Date: 3 March 2023

Application by Ørsted Hornsea Project Four Limited (“the Applicant”) for an Order granting Development Consent for the proposed Hornsea Project Four Offshore Wind Farm (“Hornsea Project Four”)

REQUEST FOR INFORMATION

G7.13
Ver. A

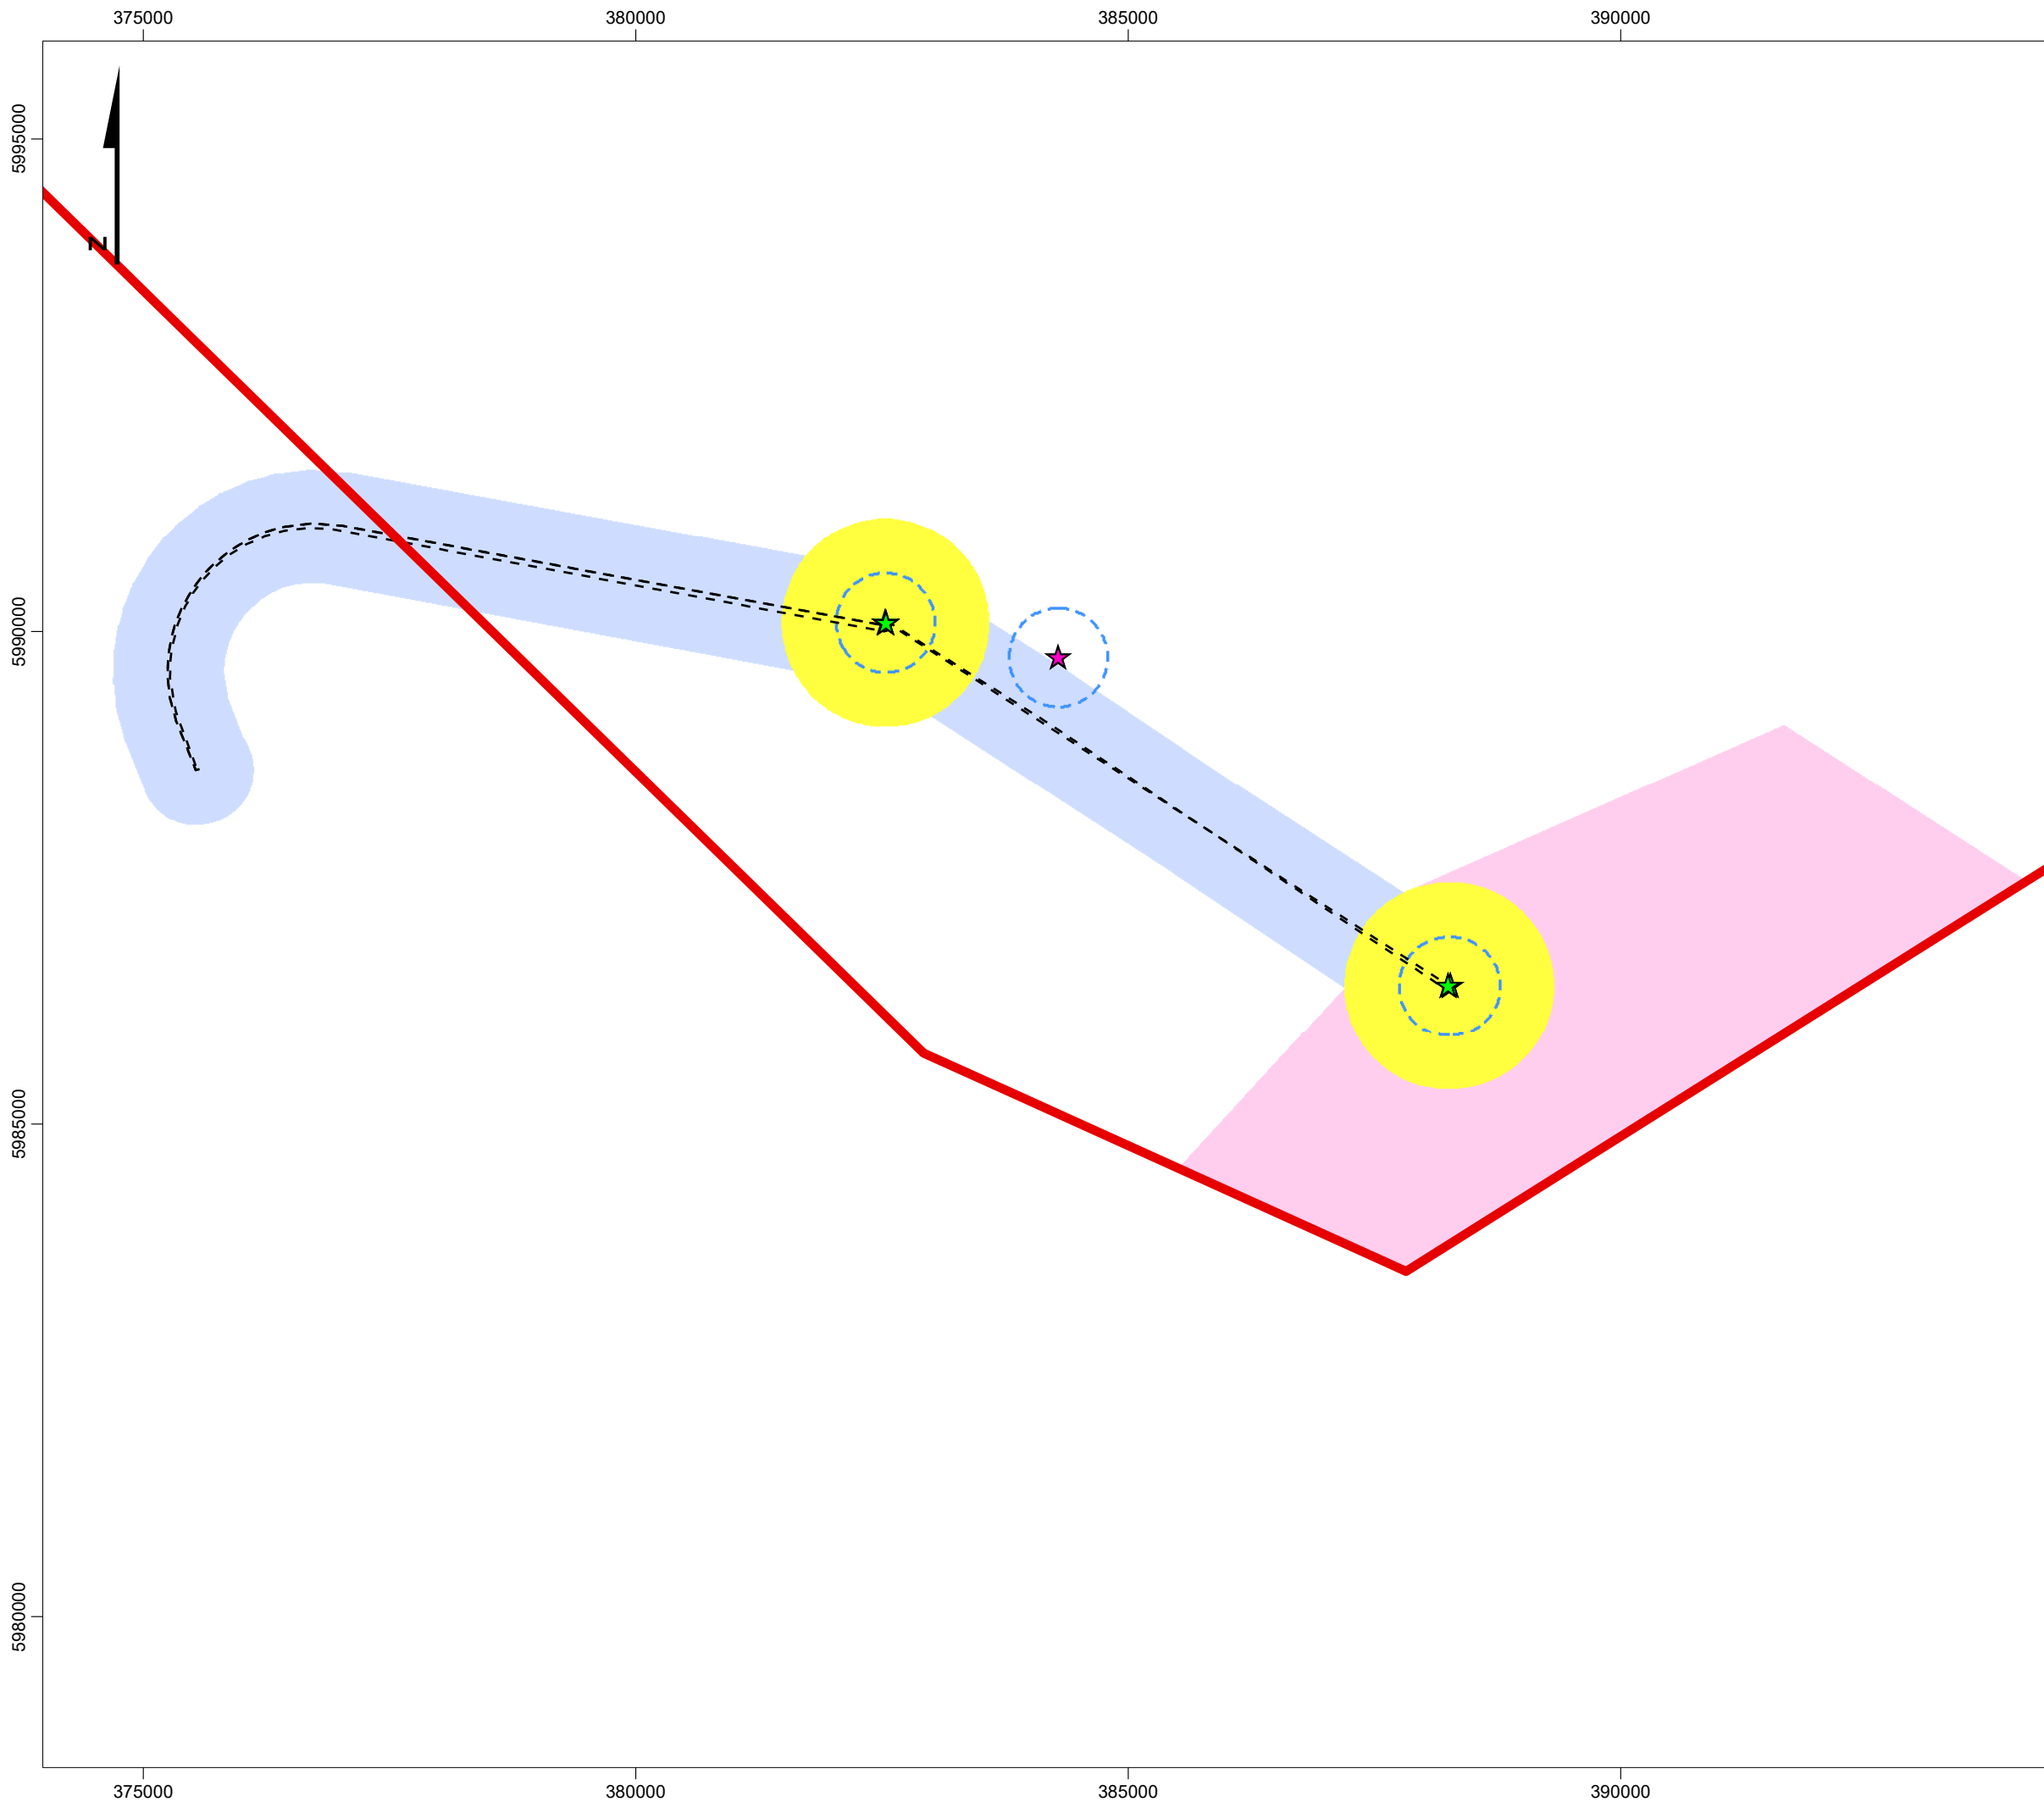
10. The Secretary of State notes that in their response to the letter from the Secretary of State dated 16 December Harbour Energy provided a number of options for an aviation corridor around the Johnston wellhead and made reference to expected new Civil Aviation Authority guidance (in particular the Policy and Guidelines on Wind Turbines (CAP764) and the Specific Approval for Helicopter Offshore

Operations (SPA HOFO)). The **Civil Aviation Authority** is asked to provide any update or further information as to when any new guidance is expected to be published.
